# CITY OF ALBUQUERQUE

March 30, 2018

**RE: Family Dollar  
1400 Gibson Blvd SE  
Grading Plan  
Engineers Stamp Date: 3/9/18 (L15D049)**

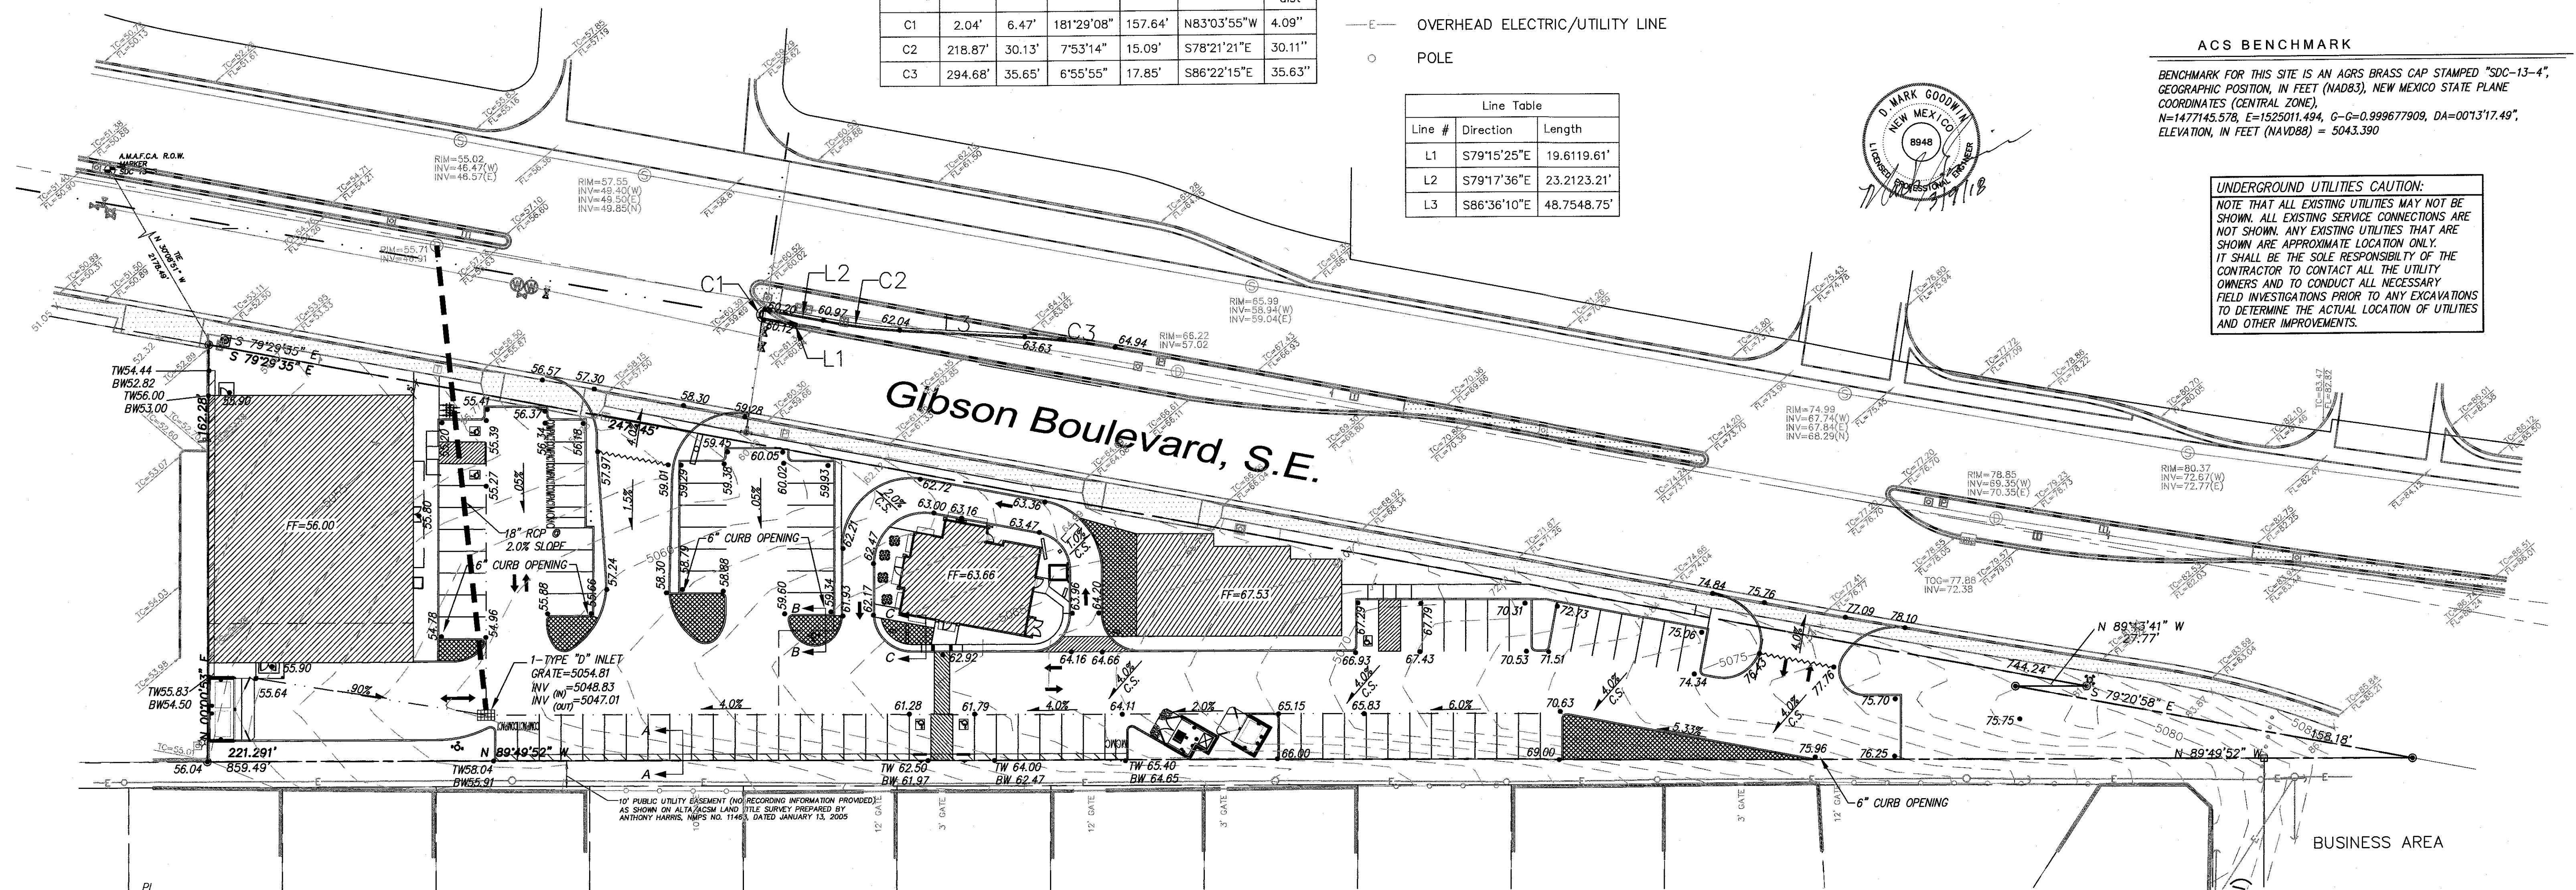
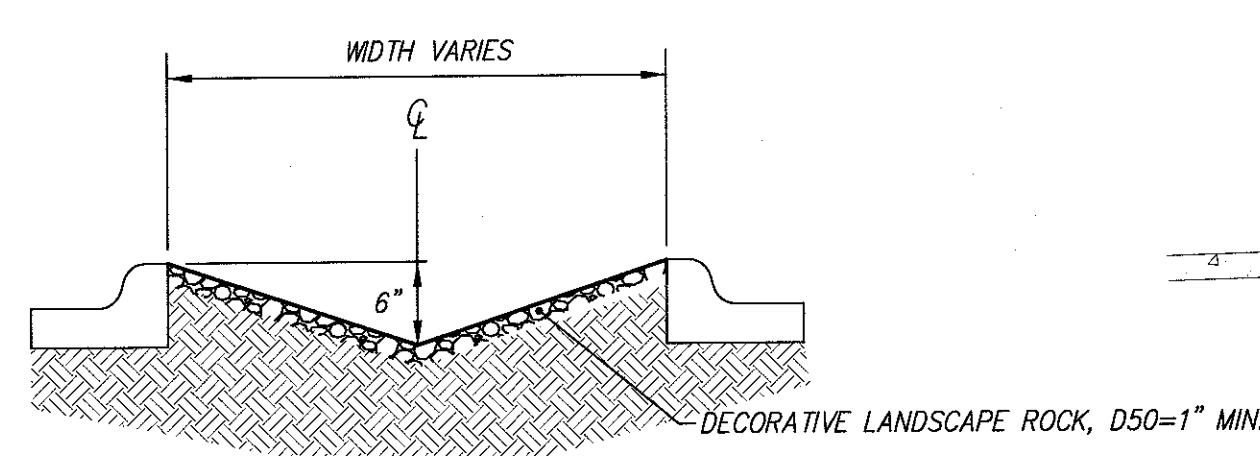
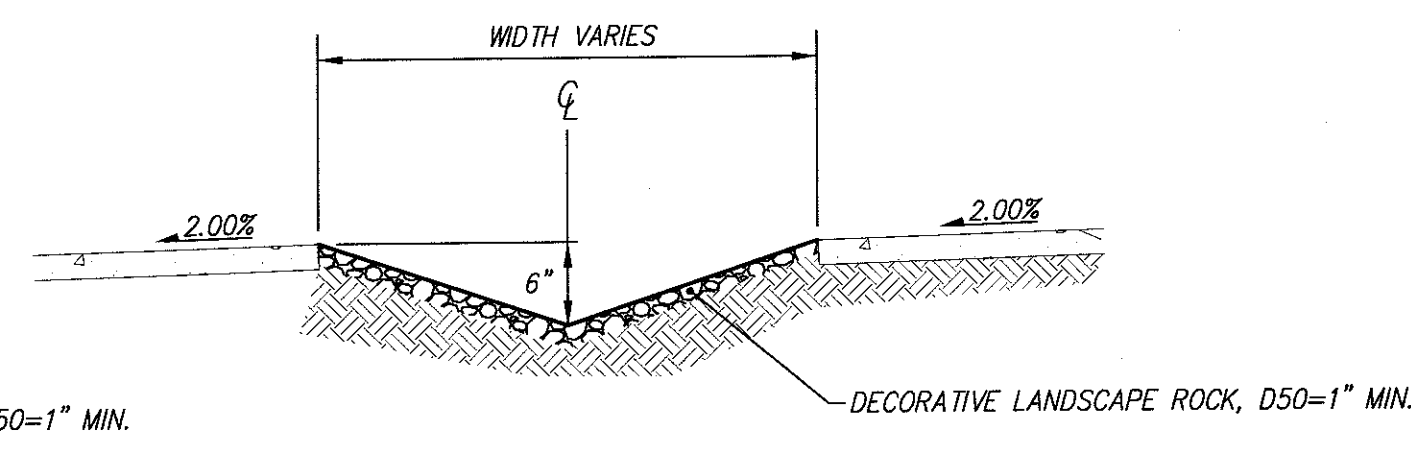
2. Clarification and additional detail is needed on the emergency spillway:
  - a. Increase the density of spot elevations and include top of curb/flowline elevations in the vicinity of the Family Dollar, correct the grade line from 0.05% to 0.5%, and provide the spillway elevation.

- b. Show the maximum water surface elevation and extents in the parking lot if the backflow preventer is engaged and water needs to pond in the parking lot.

- c. Provide a profile for the spillway channel (water surface, slopes, top/bottom of channel).
  - d. Provide a section for the channel showing the adjacent grades for the sidewalk, ROW, and Family Dollar. It seems there may be a drop-off from the back of sidewalk to the channel bottom and a pedestrian safety rail may be required.

- e. Build notes are needed for the channel as well (concrete type, thickness, reinforcement, etc.).
  - f. Include sidewalk culverts with capacity to pass 6.76cfs; these will be built by WO, but should at least be sized and shown on the grading plan.

3. Please put the build note for the private inlet back on the plan.
4. A Private Facility Drainage Covenant is required for the stormwater quality ponds. The original notarized form, exhibit A (legible on 8.5x11 paper), and recording fee (\$25, payable to City of Albuquerque) must be turned into DRC (4th, Plaza del Sol) for routing. Please contact Charlotte LaBadie (clabadie@cabq.gov, 924-3996) or Madeline Carruthers (mtafoya@cabq.gov, 924-3997) regarding the routing and recording process for covenants.

5. How do the roofs drain? Show on plans how they will be routed through the first flush basins.
6. Payment of the Fee in Lieu (Amount =  $883CF \times \$8/CF$ , per grading plan, stamped 3/28/18) for the required first flush volume must be made.
